2 MG ROLLING HILLS TANK

**SITE DEVELOPMENT PLAN
FINAL DRAINAGE REPORT**

January 2021

PCD Project Number: PPR-21-006

**WIDEFIELD WATER AND SANITATION DISTRICT**  
 ROLLING HILLS 2MG POTABLE WATER TANK AND INLET PIPELINE  
 SITE DEVELOPMENT PLAN  
 PROPOSED SITE DRAINAGE

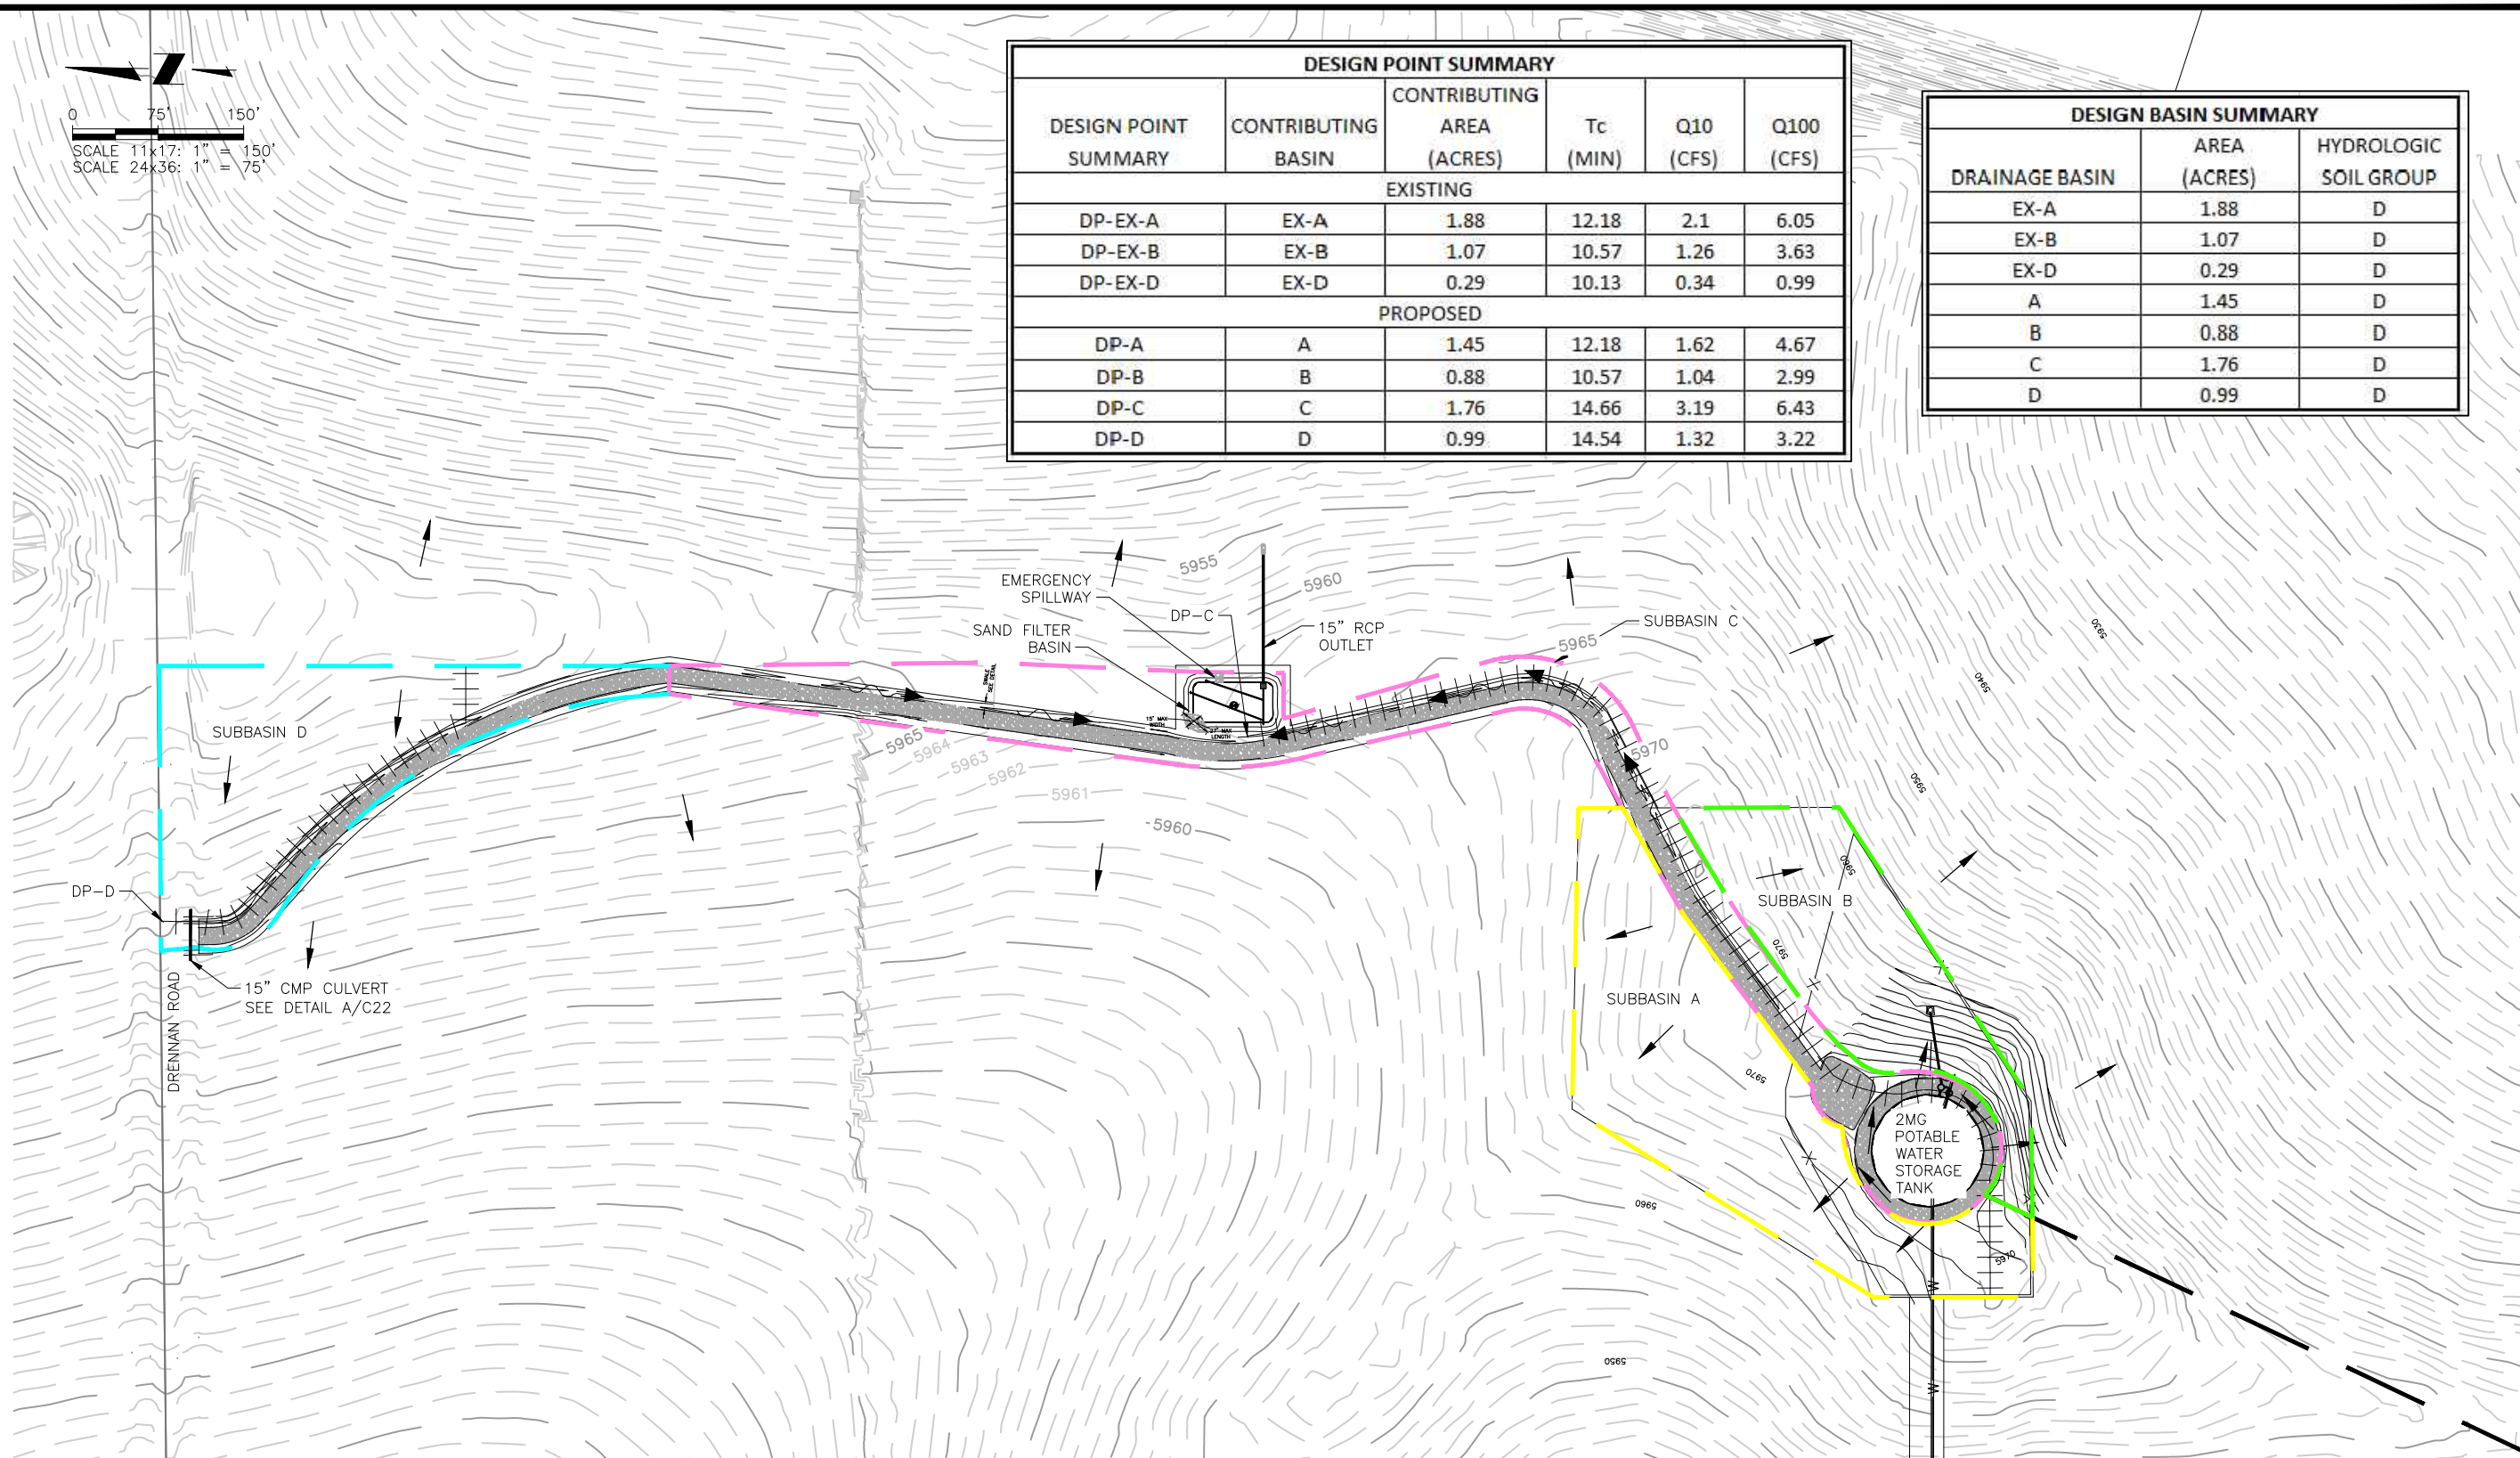
Please state whether or not the ditch is adequate for the developed flows or whether any improvements are needed. How does this developed flow at DP-D compare with the historic flow at this ditch?
